Subject: FW: BE/148/20/OUT - Nursery Fields (Chalcroft Lane - Bognor Regis) - PROW COMMENTS

Subject: BE/148/20/OUT - Nursery Fields (Chalcroft Lane - Bognor Regis)

I am emailing you further to a recent planning application we have been made aware of and wanted to make some comments from a Public Rights of Way perspective. There is mention of the a couple of public footpaths through the development and proposals for them and below are some points to consider for the applicant setting out what we would support and additional links to the network that could be contributed to/delivered as part of this development.

LAND USE AND ACCESS PARAMETERS PLAN (REF: 01304_PP_01_P1)

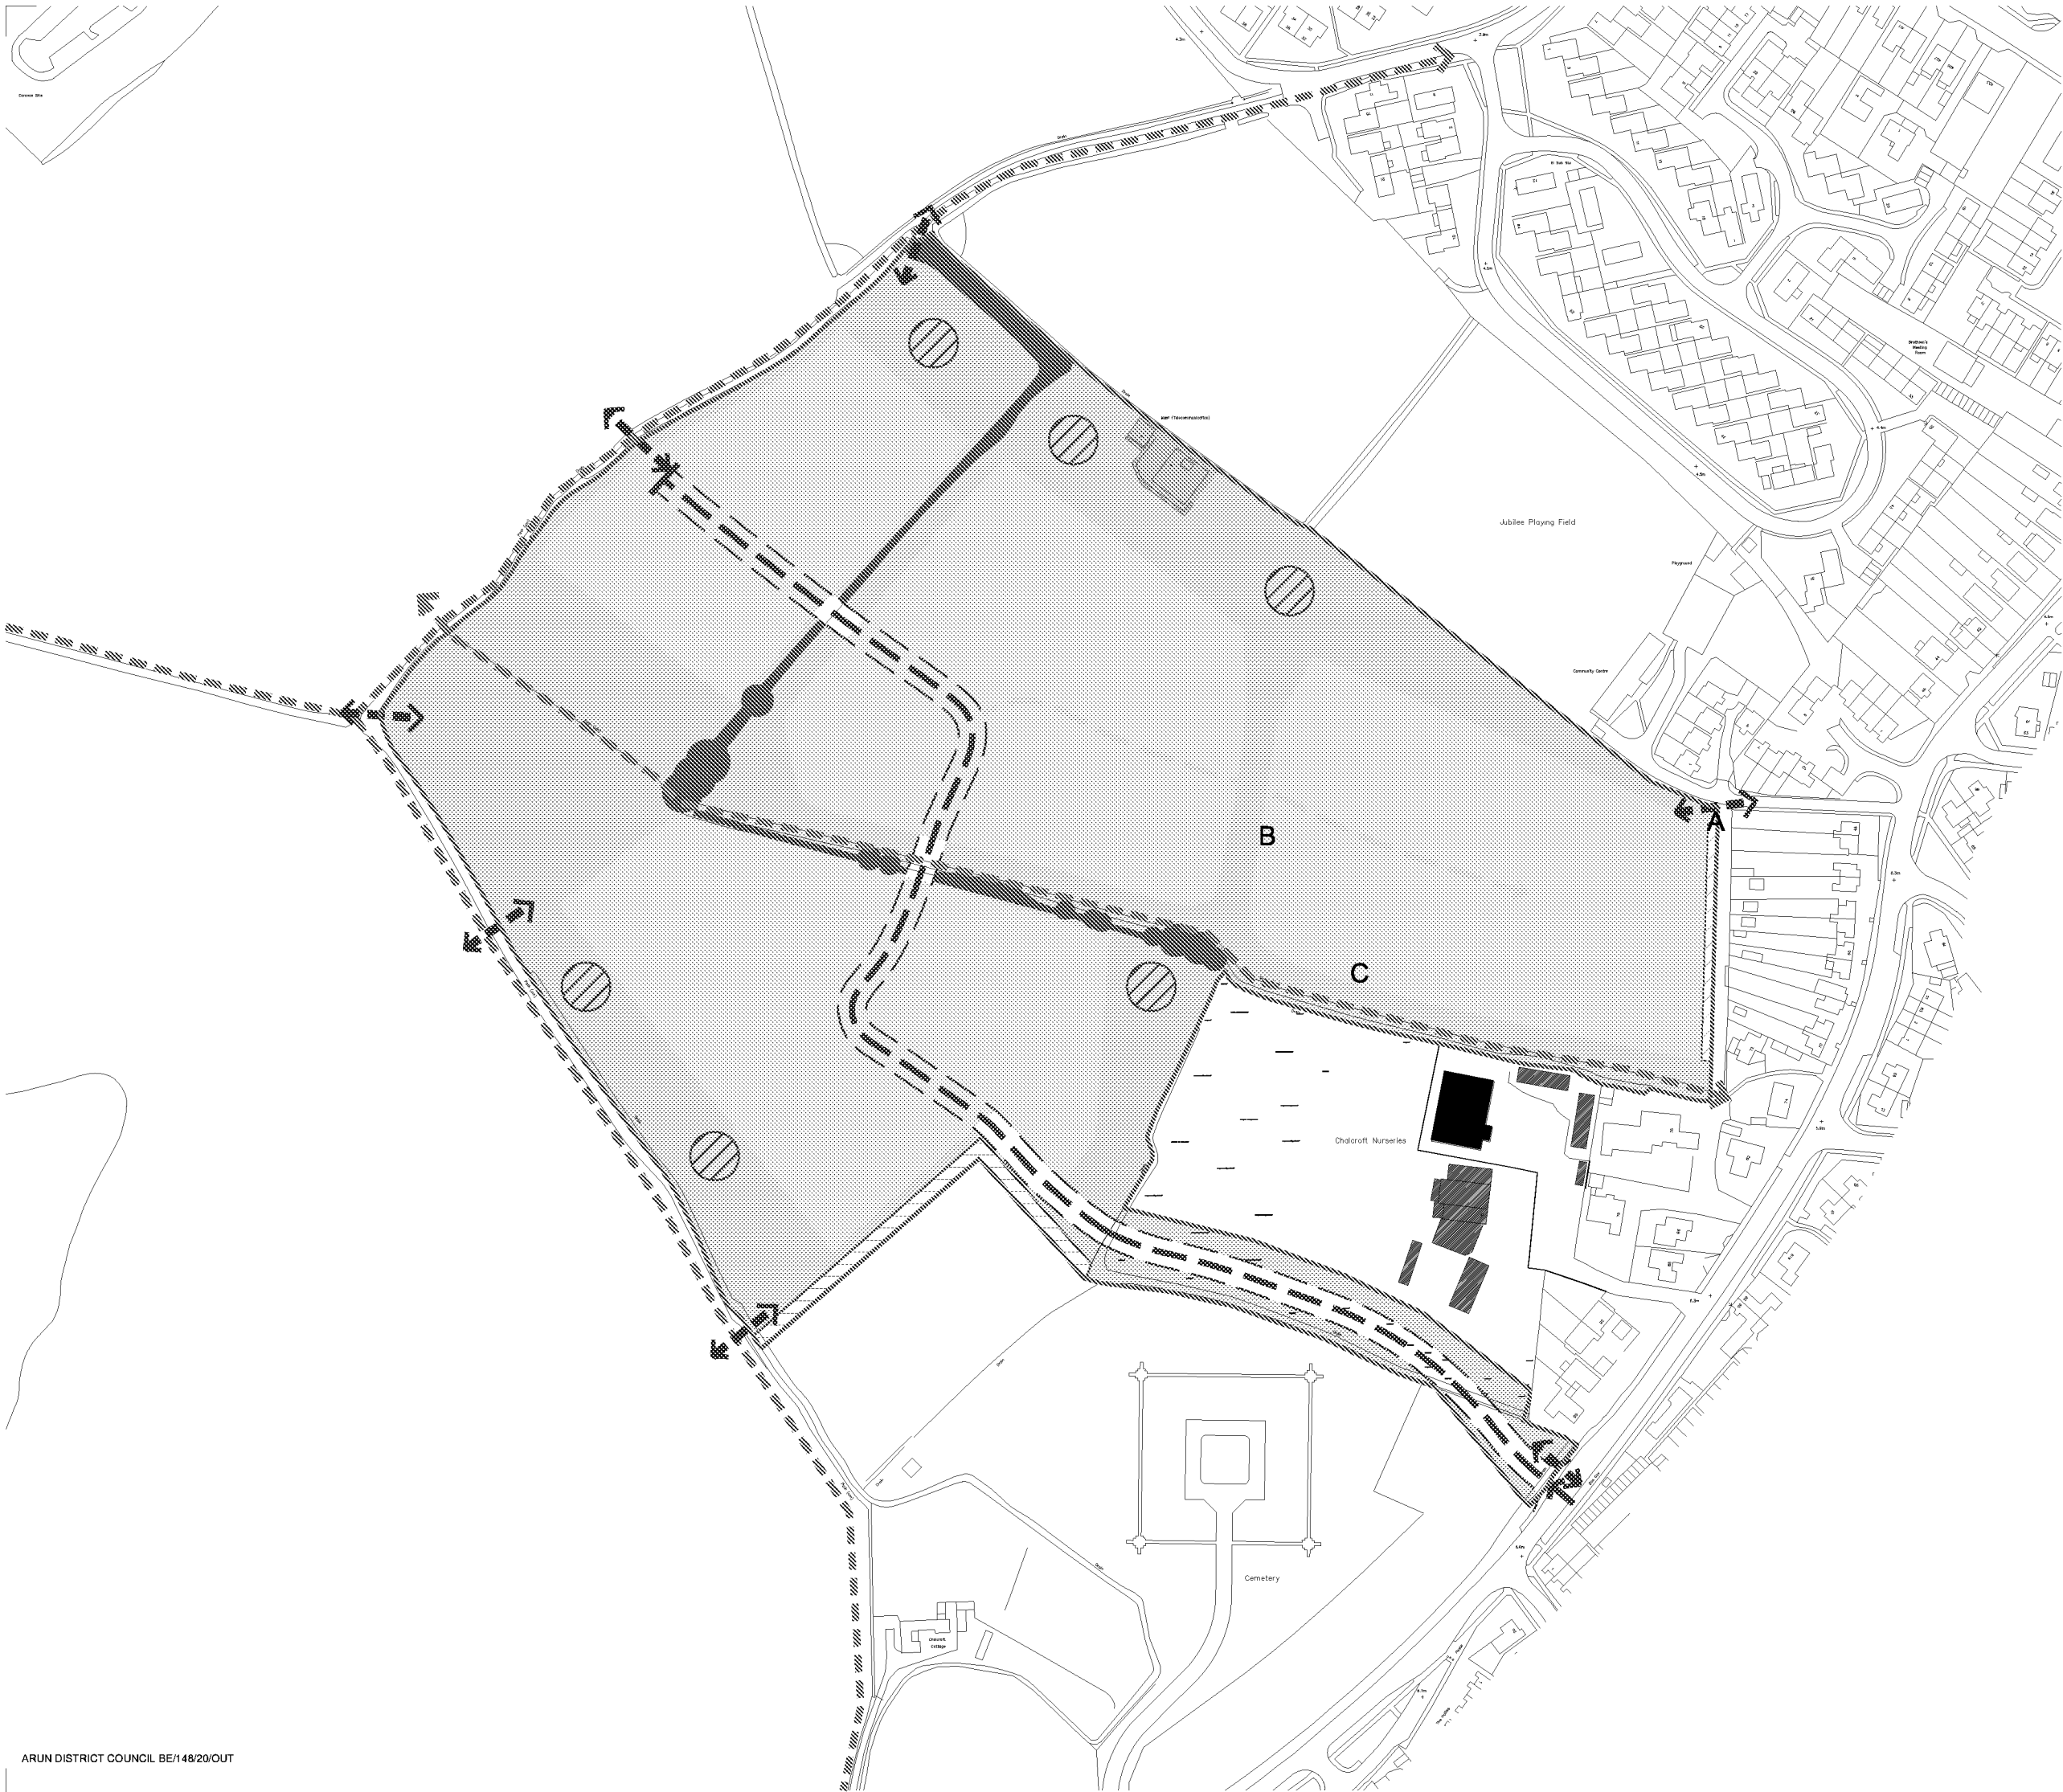
- WSCC's PROW team support the proposal to upgrade FP 134 within the development site to a public bridleway and this will provide connectivity north east toward Chichester Road. This would allow better commuting links and leisure access off road from the proposed new development to facilities and the existing cycle link between Bognor and Chichester. We would look for upgrade to Bridleway so it increases the number of users that are able to utilise this facility, rather than simply a cycle link

- The wider aspiration in this area is to create a Bridleway link north west toward Chichester through this site and beyond toward Lagness so contributions toward improvements outside the red line boundary (FP137) would also be welcomed to help deliver the aspiration giving improved access to walkers, cyclists and horse riders. With limited Bridleways on the coastal plain the opportunity to improve this network and improve sustainable transport and leisure offerings toward Pagham and Lagness would be very beneficial.

- FP136 through the proposed development would also provide a useful link. I appreciate the applicants comments about the exit onto Chalcroft Lane along the existing footpath being a challenge for equestrian users due to limitations on the path width at its eastern end but would support the upgrade of this route to allow for cycling along much of its length before it turns in a northerly direction to join to an existing cycle link near the community hall. This would help to provide a cycling option that would be able to tie in with proposed Bridleway upgrades and north west and north east avoiding busy roads and help to reduce the reliance on private motorised vehicles.
